Y/124/21/L

Wayside Cottage Burndell Road Yapton BN18 0HP

Listed building consent to remove old thatch and pitch-based membrane from existing roof structure, treat as necessary for woodworm. Cut and pitch new roof rafters alongside existing and install collar ties between alternating rafter ties. Rethatch in Norfolk reed with straw block patterned ridge. Wood fibreboard and lime plaster finish to underside of new collar-ties to leave old ceiling joists exposed. Alter the roof to the single storey extension including the removal of existing roof covering and form a small parapet wall, install new rubberised roof covering. Refurbish dormers & side roof. Install heritage style rainwater goods. Remove existing rotten windows and replace with hardwood single glazed Georgian bar casement windows. Remove modern concrete & screed floor to ground floor and install under floor heating and a natural hydraulic lime, aggregate & screed fibre mix

Window Profile:

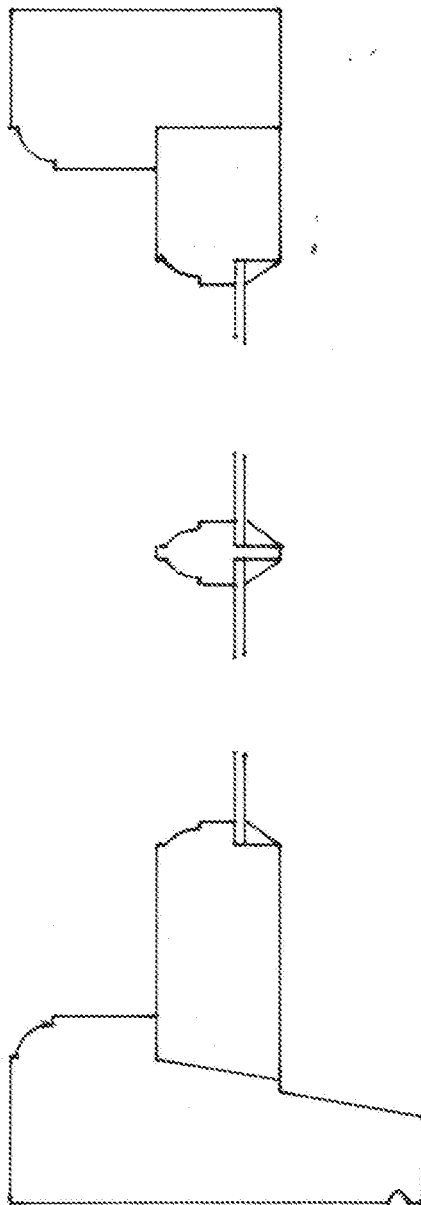
It is clear the existing windows are of modern design and construction which include fan lights and aside from being in poor state of repair, are not appropriate for the listed building. The proposal is to replace them with something more appropriate, and a vertical section of the windows has been provided. It might help to see a horizontal section so as to understand if the opening casements are to be flush or a 'storm design'.
